Copse View, 2 Arundel Road, Poling, Arundel, West Sussex. BN18 9PW

18th July 2015

Objection Against Application PO/3/15/HH – Proposed Extension to 3 Arundel Road, Poling.

PROPOSED FRONT ELEVATION
North

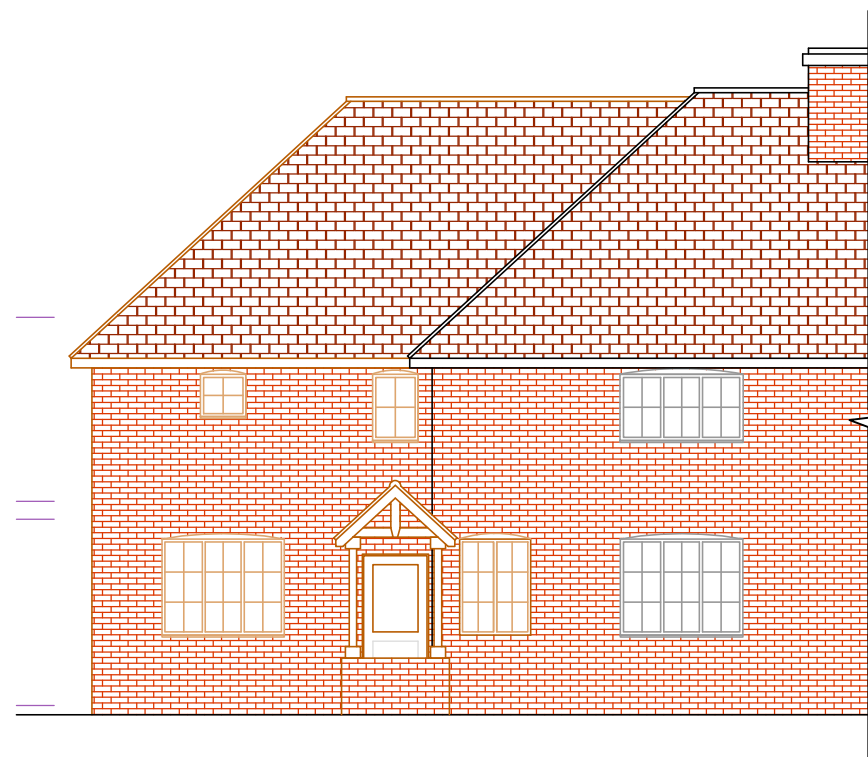
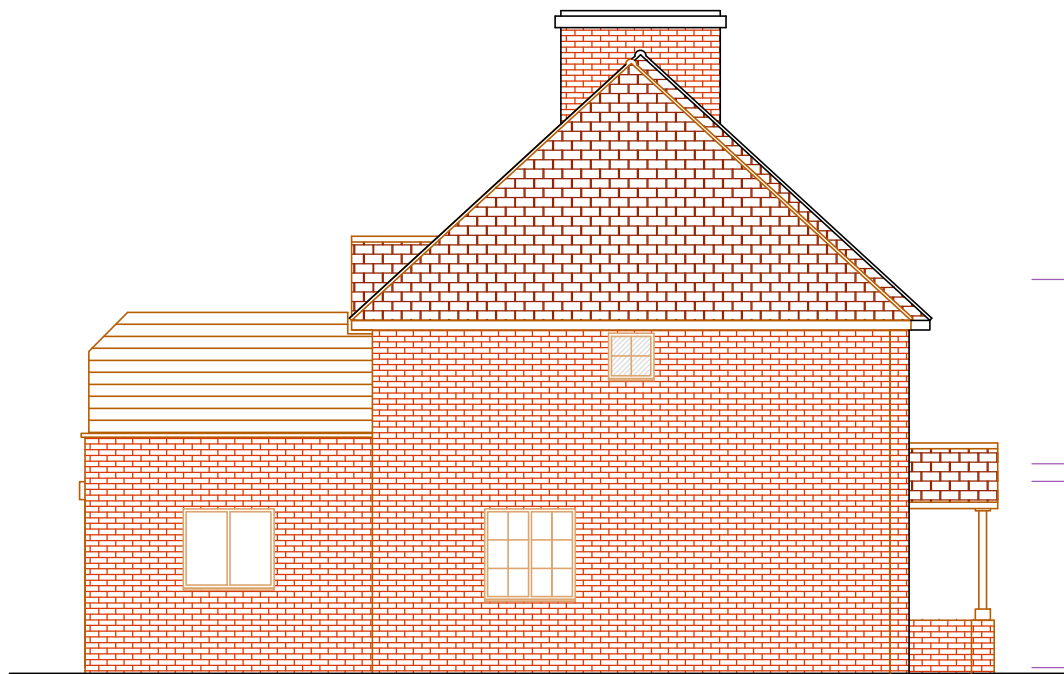
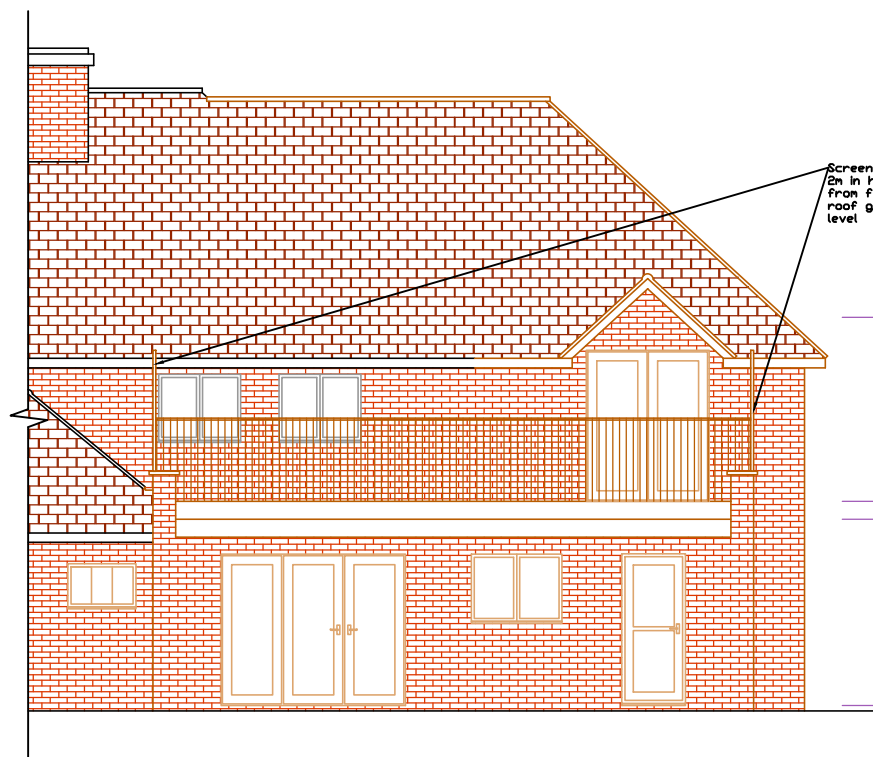
- 1 The new plans show a significant change to the North elevation. The main extension is now recessed back from the original building line and, unlike all the other houses in the street that have been extended, this will look extremely out of place. It will in fact make the building look a little like someone has tried to extend it but not had the money or skills to finish the job properly!

- 2 Looking from the northeast, with all the different lines from two different ridge heights, the porch, the French doors to the balcony and the balcony itself, this proposal will look a complete hotchpotch to anyone walking or driving along the A27.

- 3 We are concerned at the number and size of the windows in the east elevation, which being so close, will look directly into our property.
- 4 We are still very concerned with the design of the Balcony. (Please see previous correspondence) As this clearly breaches Article 8 of the Human Rights Act (Article 8 – Right to respect for private and family life) we sincerely hope that this intrusion into our life will not be allowed.
